Application number: 2026/92032	
What is the application for?:	Non material amendment to previous permission 2024/92647 for erection of detache
Address of the site or building:	Land at, Occupation Lane, Off Birkby Road, Huddersfield, HD2 2ES
Postcode:	HD3 4EY

Type of comment: An objection	
Do you wish your comments to be published on the website anonymously?	Yes
I wish to formally object to the approval of Application 2026/92032 as a Non-Material Amendment (NMA) under Section 96 and any current development on the site must cease with immediate effect. The application must be refused under Section 96A and should be considered only under a Section 73 variation or a fresh planning application involving statutory neighbor consultation. 1. PROCEDURAL INAPPROPRIATENESS AND BREACH OF S96A PROTOCOL Under the Kirklees Council ‘Protocol for Non-Material Amendments Following the Grant of Planning Permission,’ an amendment is disqualified from the Section 96A route if ‘the approved footprint/siting of the building would be moved in any direction by more than one metre.’ Drawing 24.002/(AL)101 Rev A explicitly acknowledges that the setting out has been ‘adjusted to suit new legal boundary infor

Drawing title
Garage Floor Plan and Elevations as Proposed

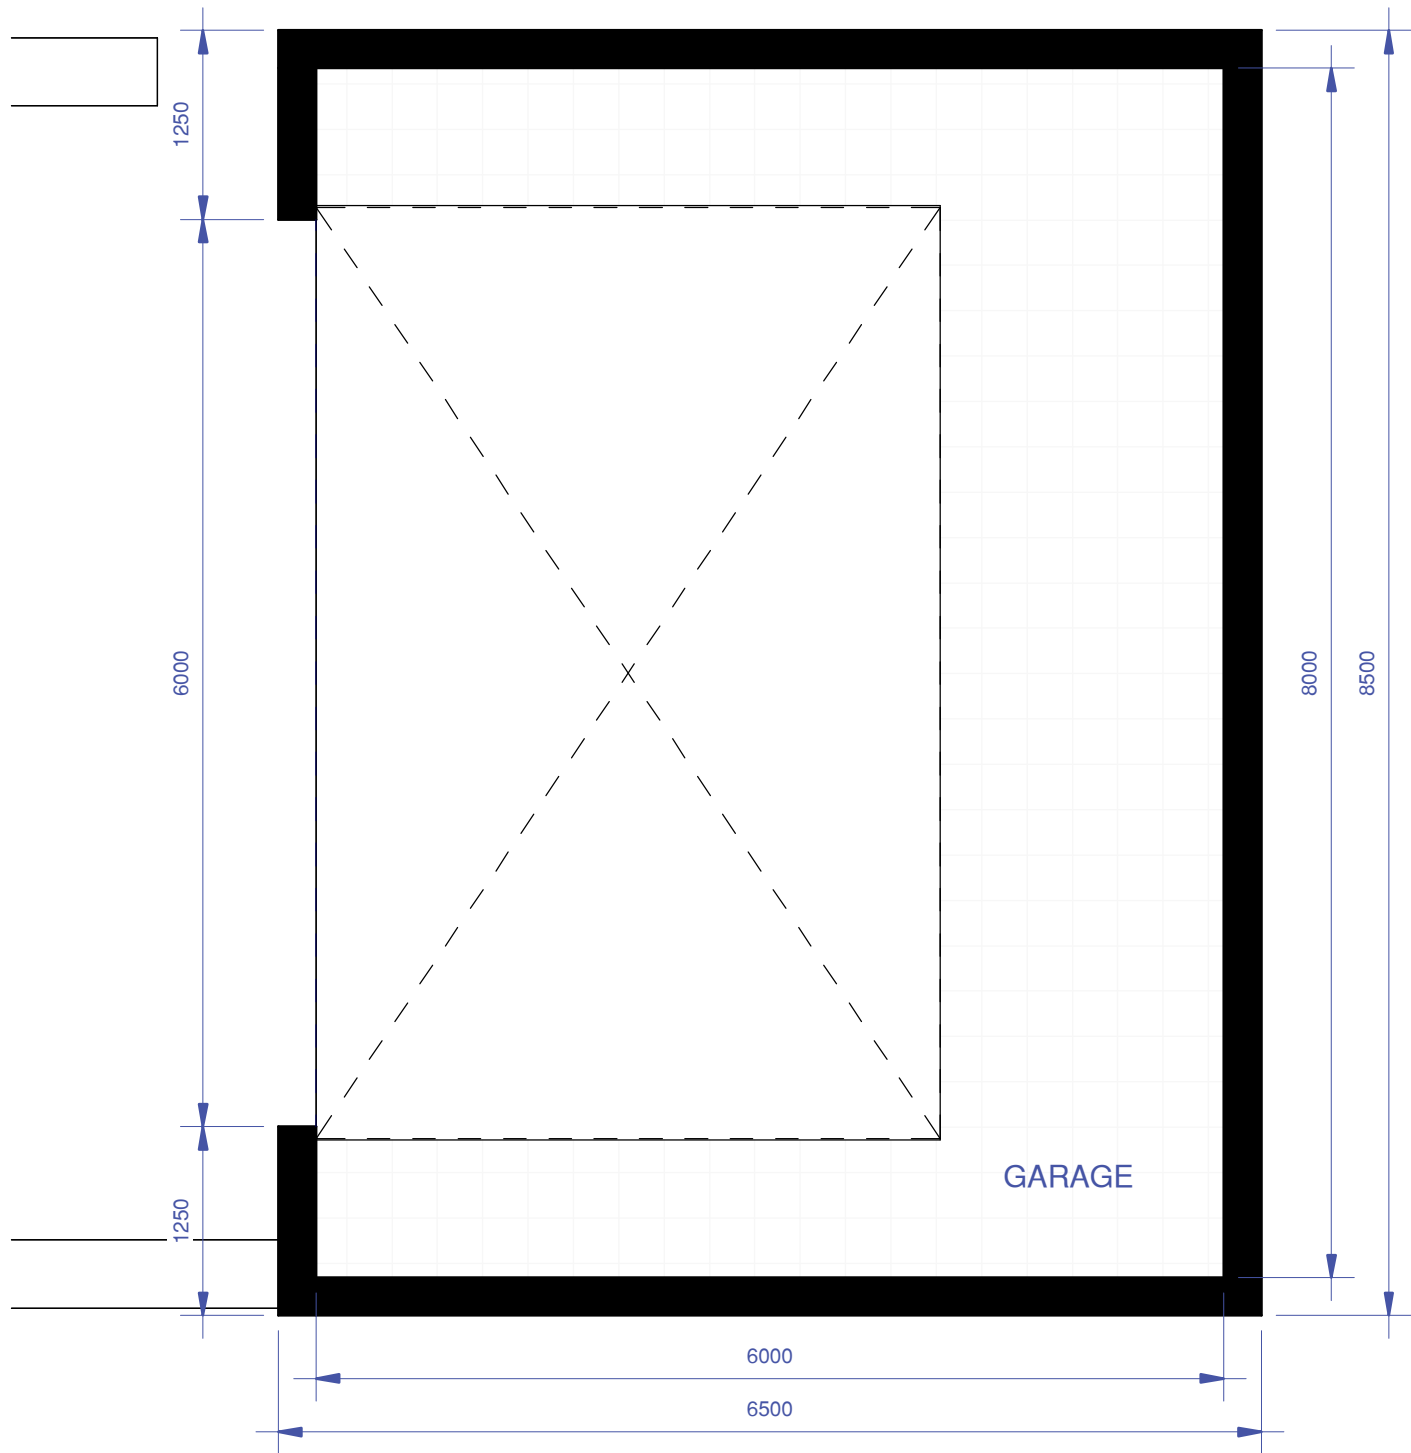
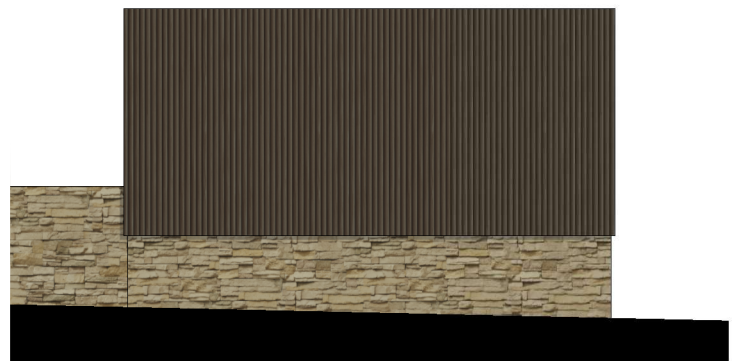
Again as per my previous point, such a substantial expansion of an accessory building on a heavily constrained, narrow backland plot cannot legally or logically be classified as 'non-material'. It changes the visual massing on the shared boundary, reduces the surrounding garden area, and alters the parking and turning arrangements at the northern terminus of the site.

Drawing no
Site Plan as Proposed

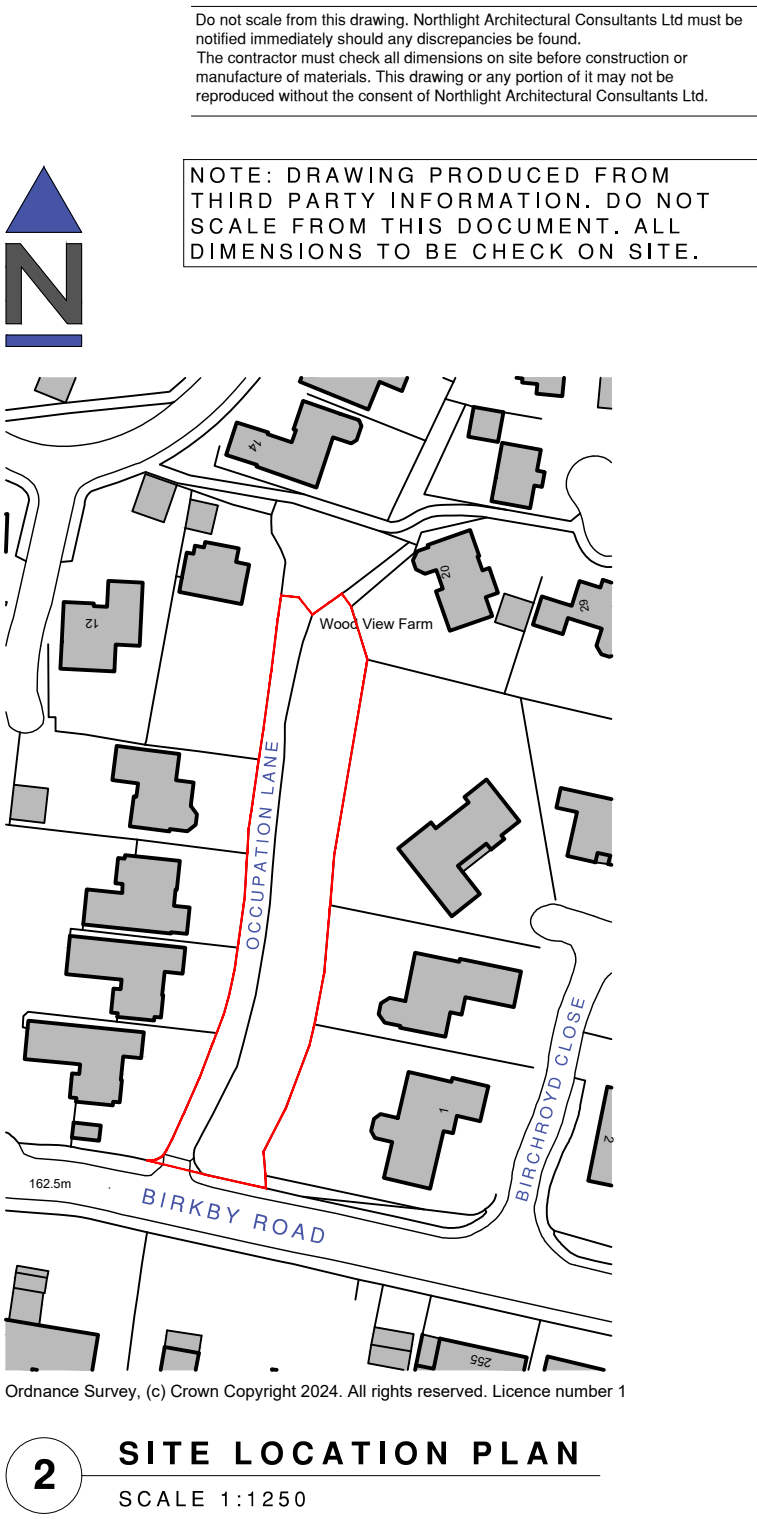
The accuracy of drawing 24.002/(EX)01 is formally contested. The red-line boundary inaccurately encloses private land and access tracks. Given the applicant's own disclaimer regarding the use of "third party information" and the instruction "not to scale," this document is an unreliable basis for determining the legality of the building's repositioning.

Drawing title
Bungalow Floor & Roof Plans as Proposed

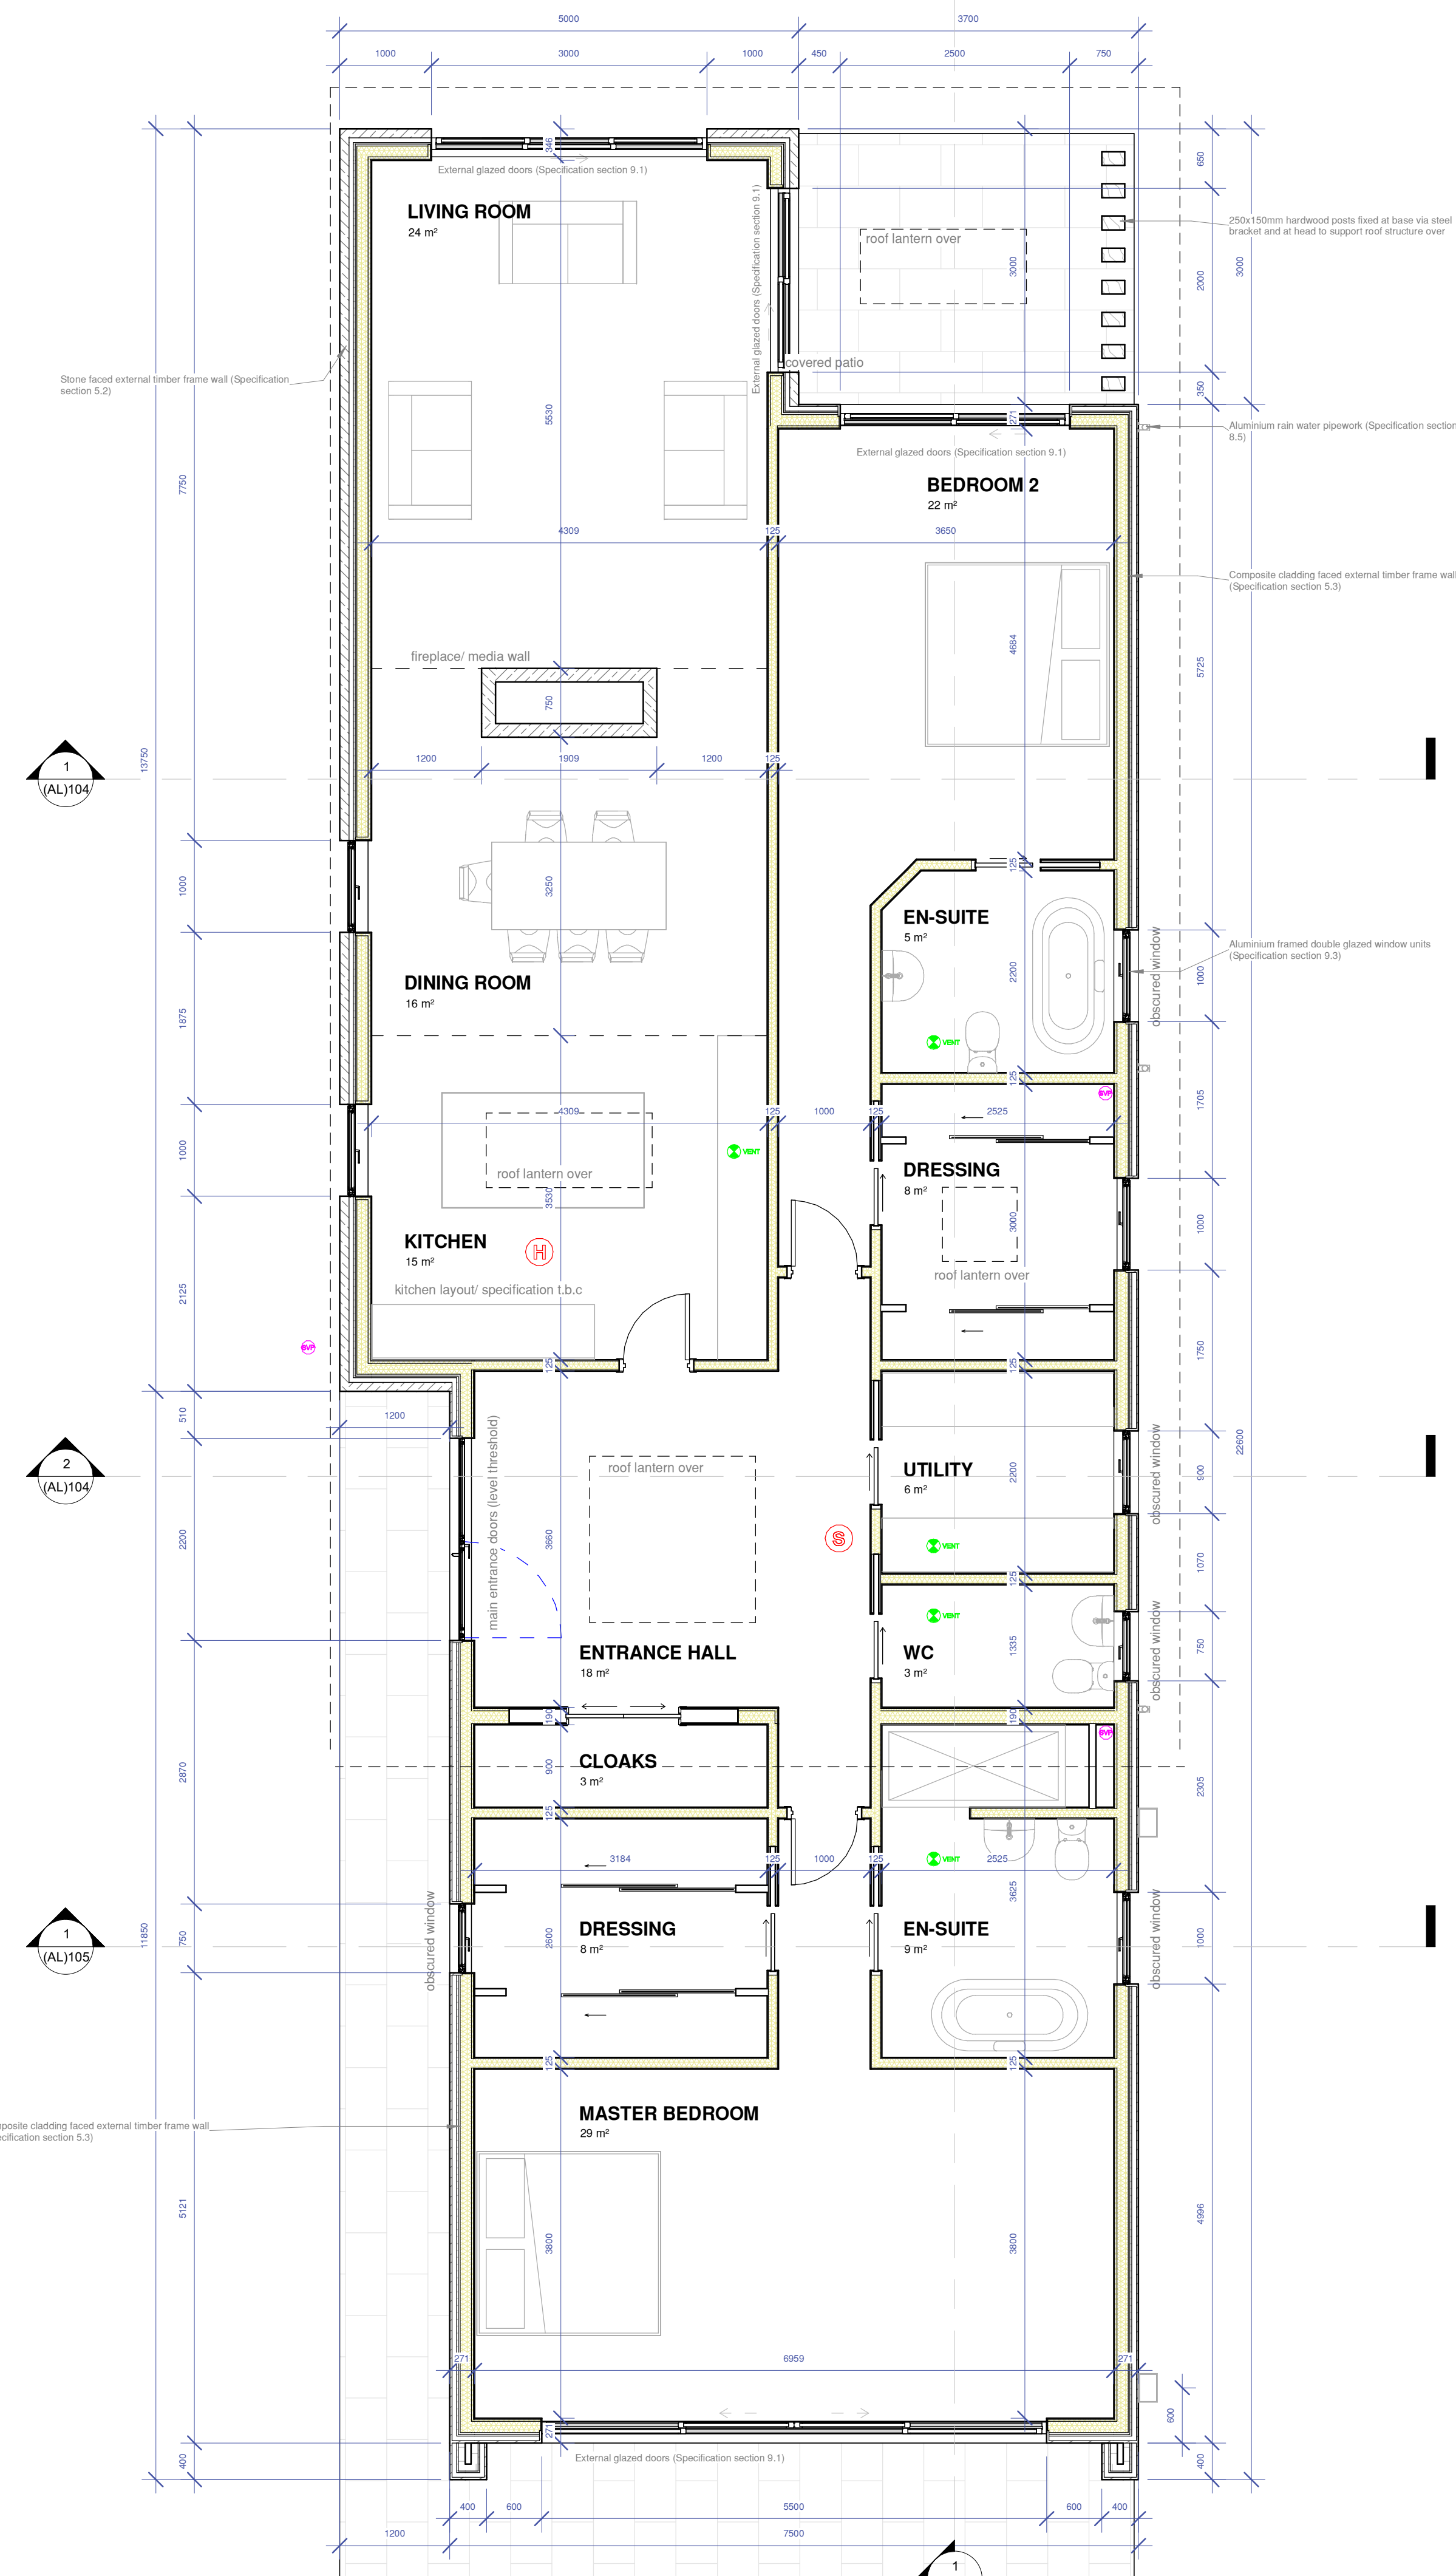
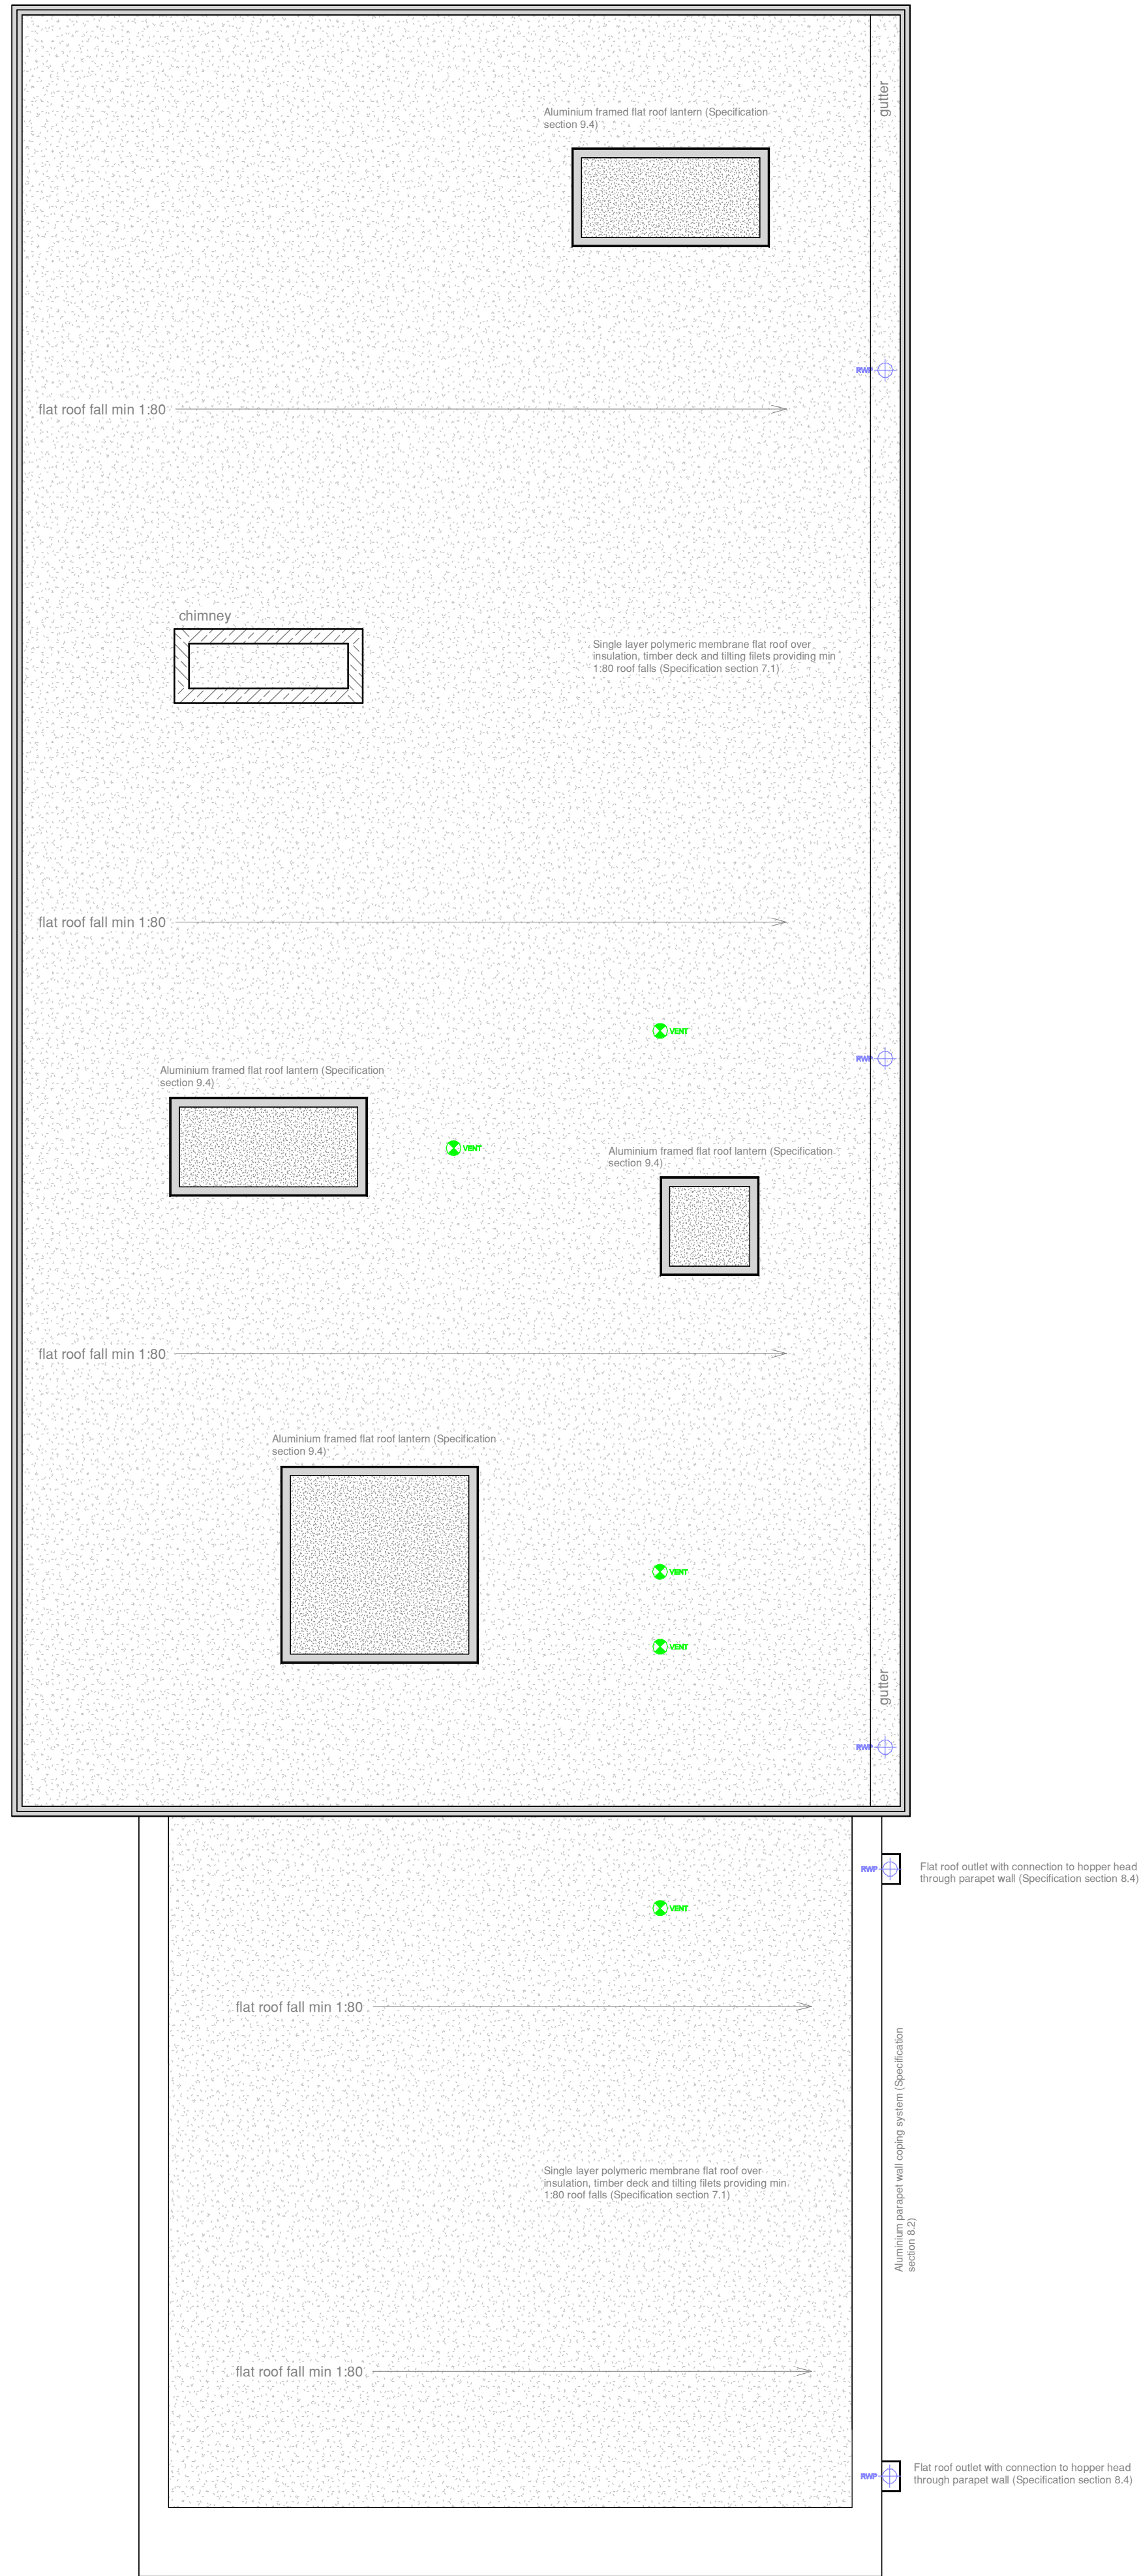
The repositioned layout introduces a primary bedroom window with direct, unscreened views into the neighboring property. This creates a detrimental visual impact and a permanent loss of privacy. Such revisions to the relationship between buildings are material in nature and disqualify the application from the NMA process, as they affect the living conditions of existing residents.
